re: **Geotechnical Review of Grading and Servicing Plans**  
**Proposed Residential Development**  
**1066 Silver Street – Ottawa, Ontario**  
to: **Concorde Properties** – Jordan Tannis – [jt@concorde-properties.ca](mailto:jt@concorde-properties.ca)  
date: July 8, 2025  
file: PG5573-MEMO.03

Paterson reviewed the following grading plan prepared by D.B. Gray Engineering Inc. for the aforementioned residential development:

- ☐ Grading Plan – 1066 Silver Street, Ottawa, Ontario, Job. No. 23056, Drawing No. C-2, Revision 10 dated July 4, 2024

Drawing No.
C-2
of **7**

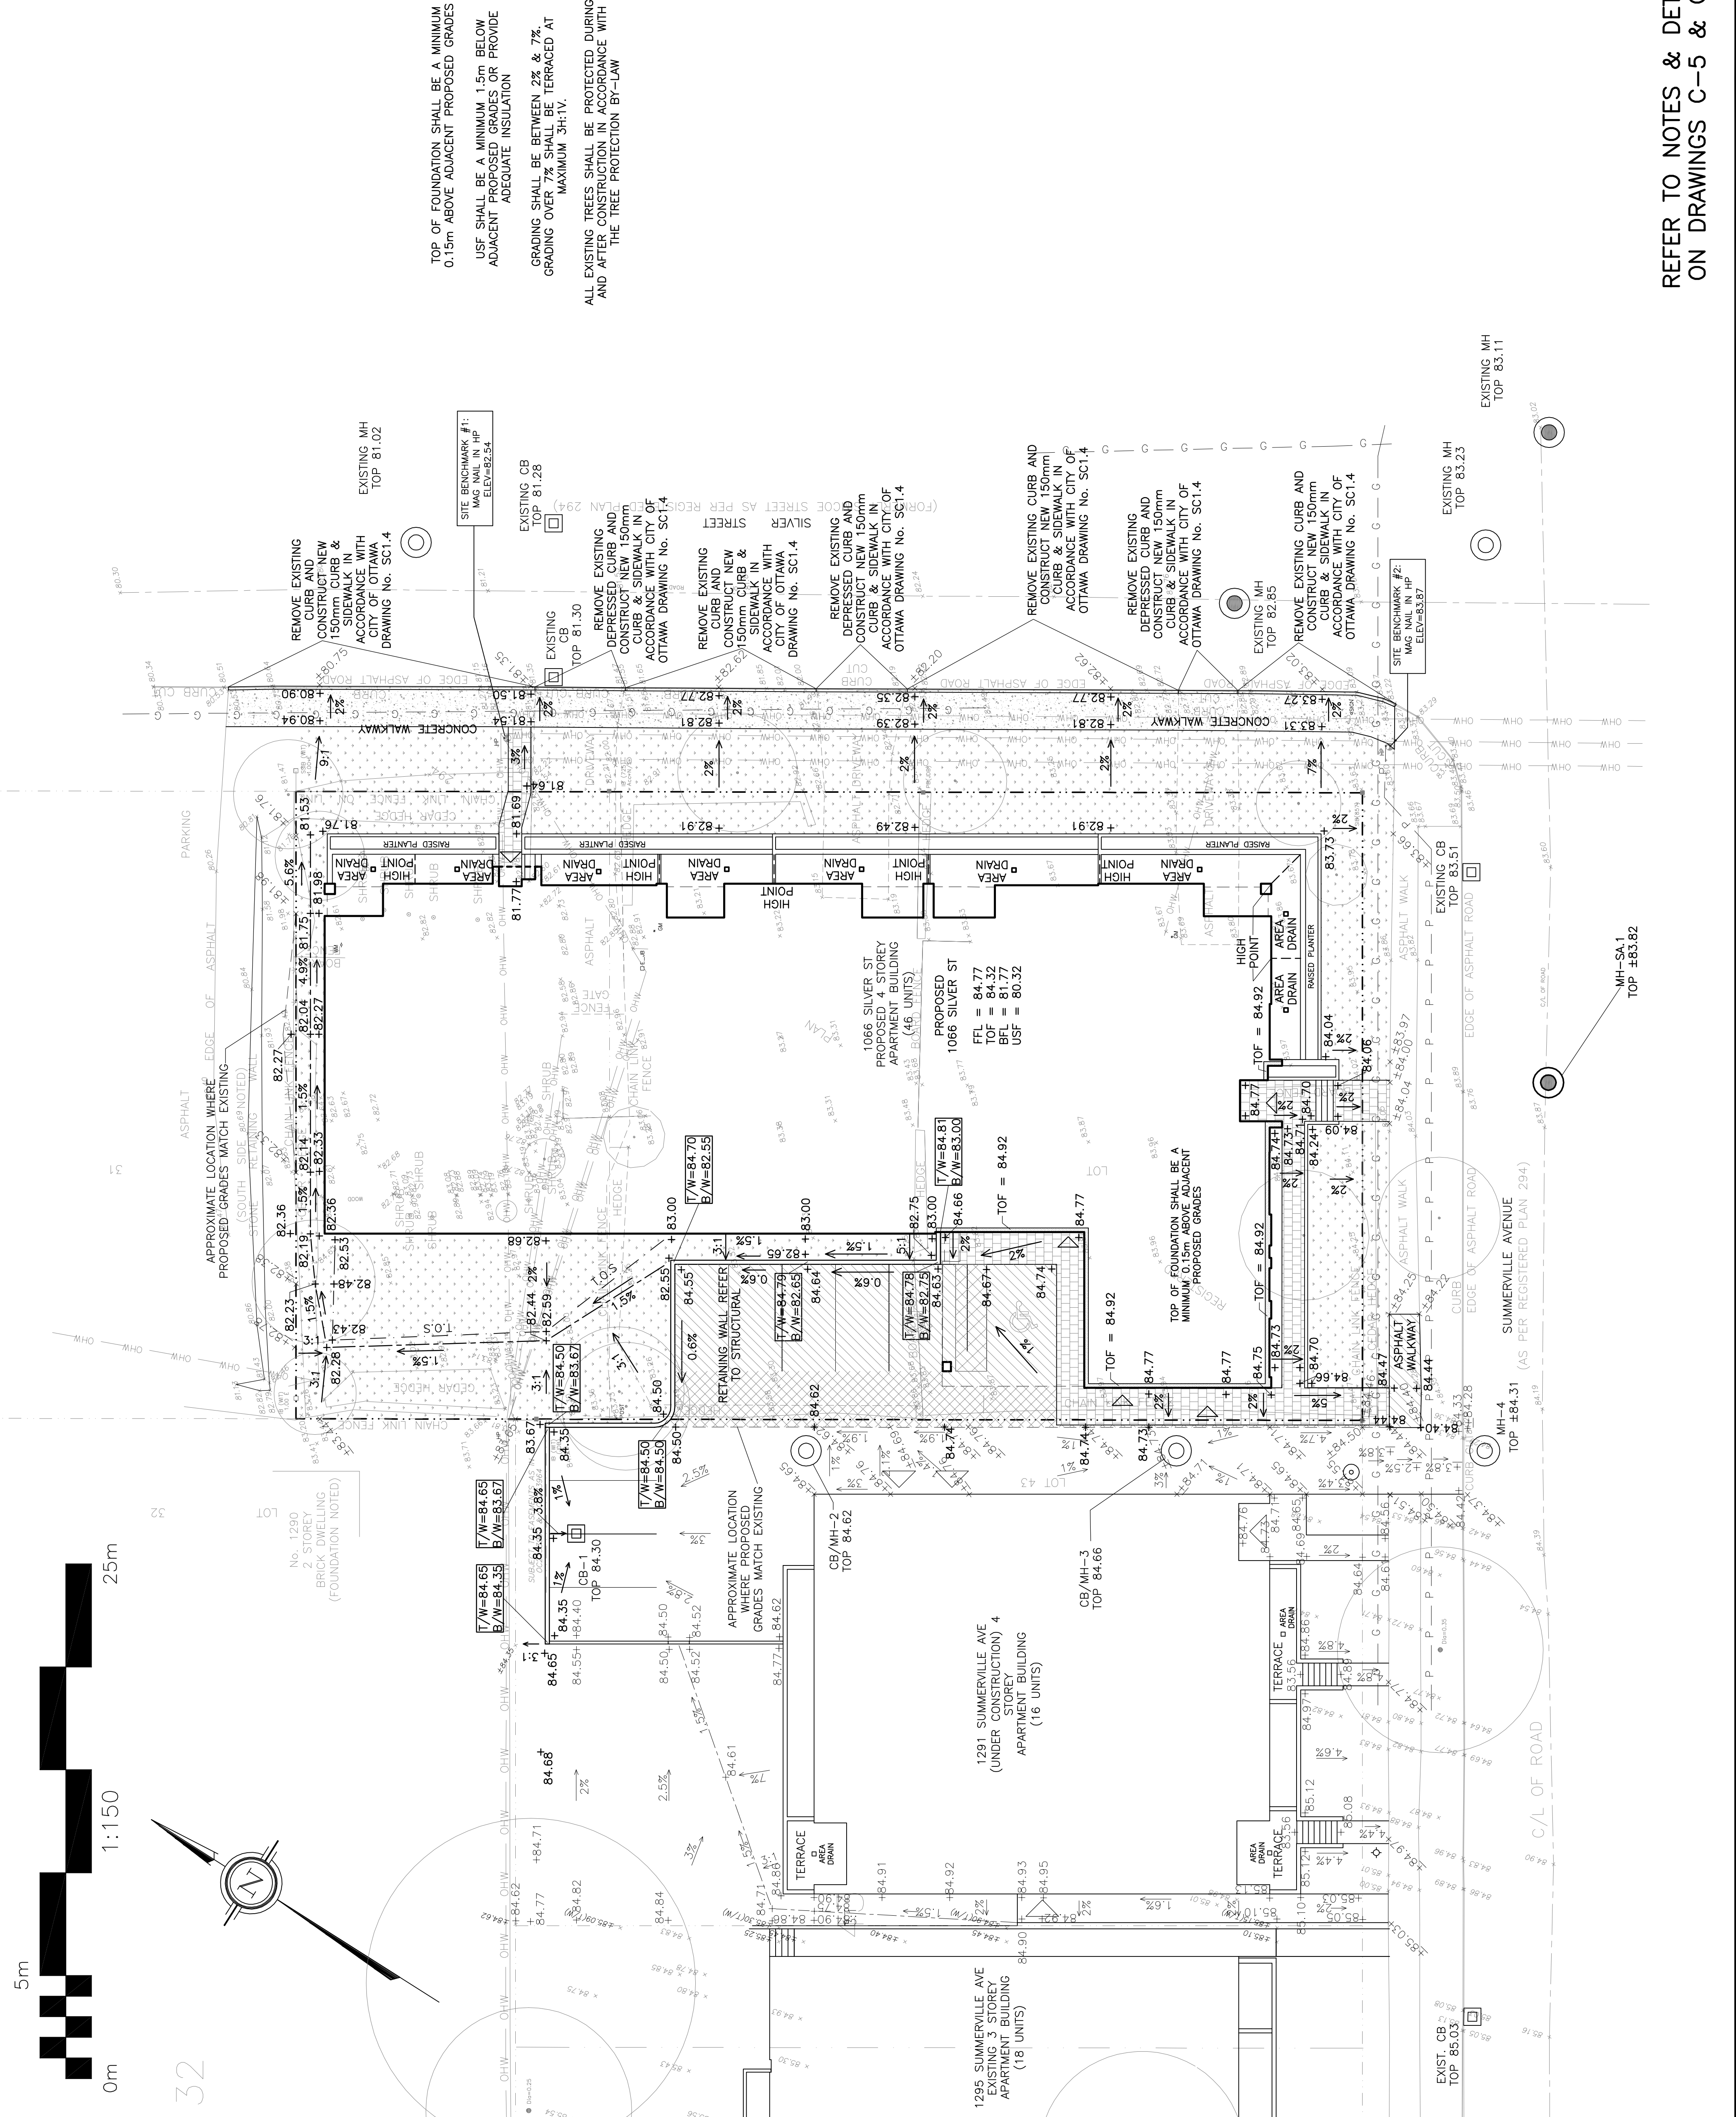
Based on our review of the above-noted drawing, the proposed grades throughout the subject site are generally within the permissible grade raise restriction of 3 m provided in the aforementioned Geotechnical Report. Therefore, the proposed grading is considered acceptable from a geotechnical perspective such that lightweight fill (LWF) or any further measures will not be required to be taken for the proposed development. Further, sufficient soil cover has been provided to perimeter and exterior pad footings such that the use of insulation to mitigate the migration of frost will not be required for the subject footings.

- ☐ The underside of footing (USF) is 2.1 m or greater below the lowest finished grade must be satisfied for footings within 10 m from the tree, as measured from the center of the tree trunk and verified by means of the Grading Plan. Based on Paterson's review, this condition is generally met from a geotechnical perspective.

Drawing No.
C-1
of **7**

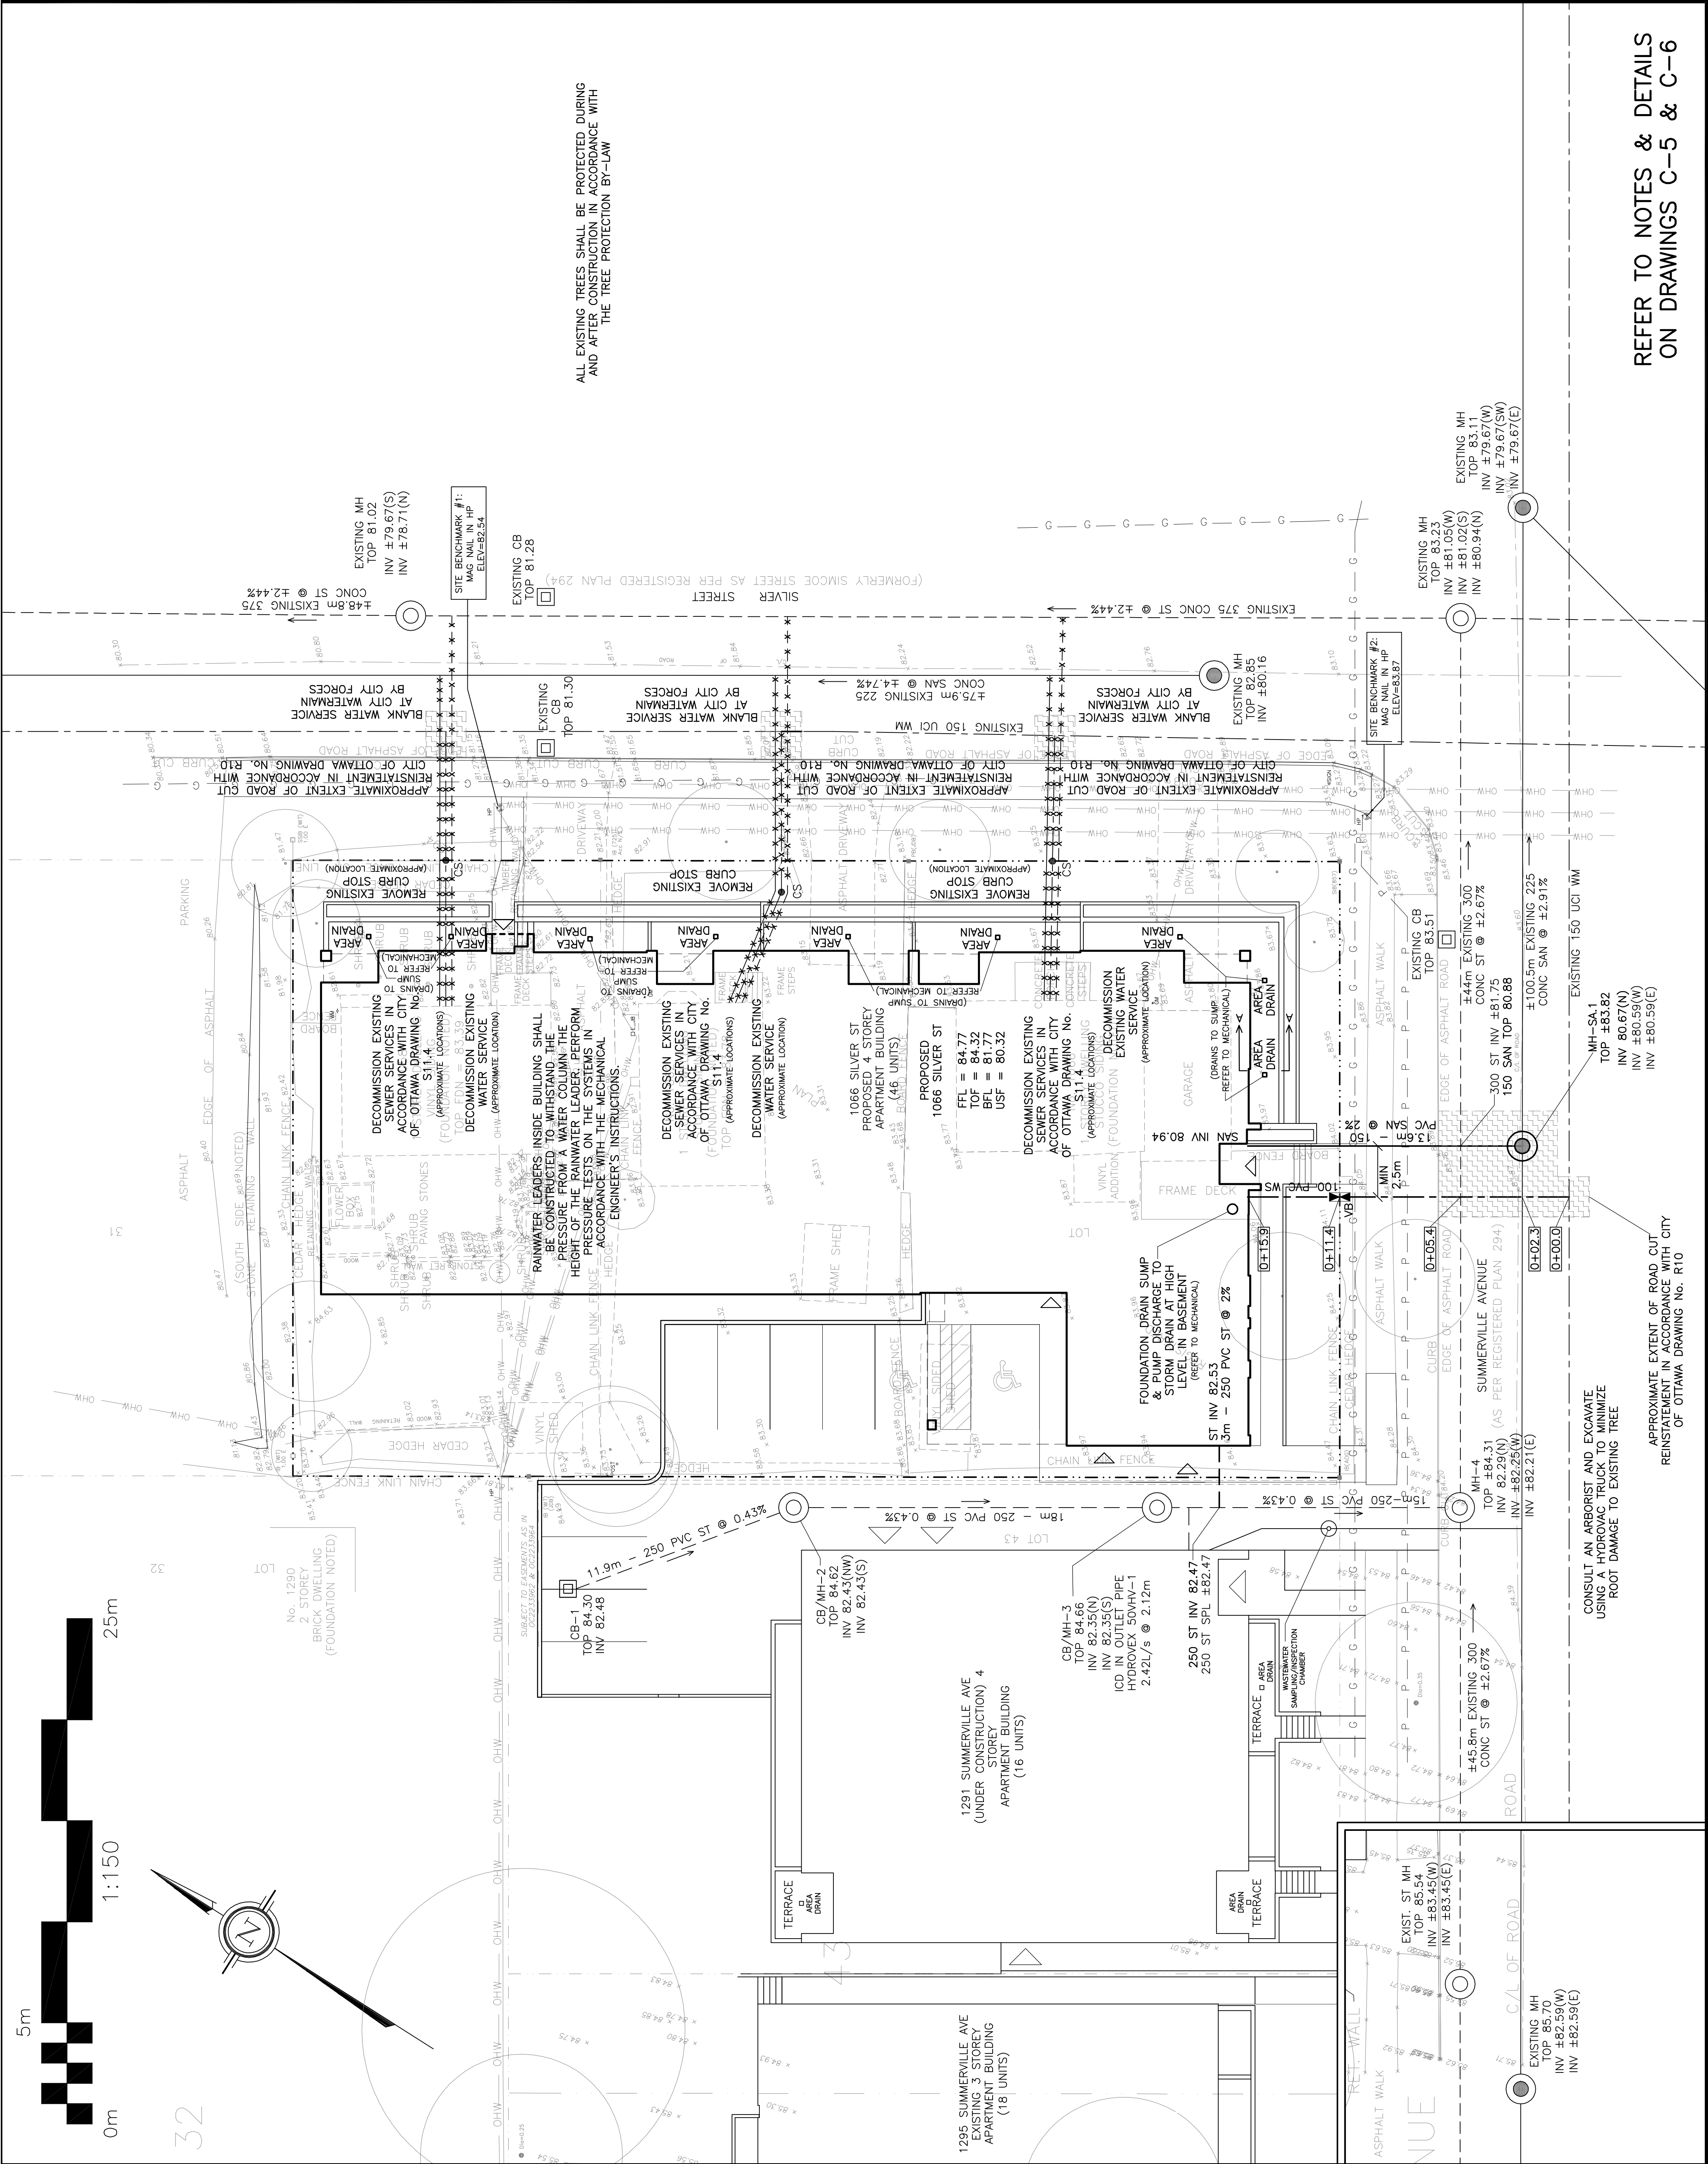
- ☐ Site Servicing – 1066 Silver Street, Ottawa, Ontario, Job. No. 23056, Drawing No. C-1, Revision 8 dated July 4, 2024

Based on our review of the above-noted drawing, the majority of the design details (i.e., lateral support of footings, adequate frost protection of services, pipe bedding and backfill), provided by Paterson in the aforementioned Geotechnical Report have been satisfactorily incorporated into the above-noted drawing.
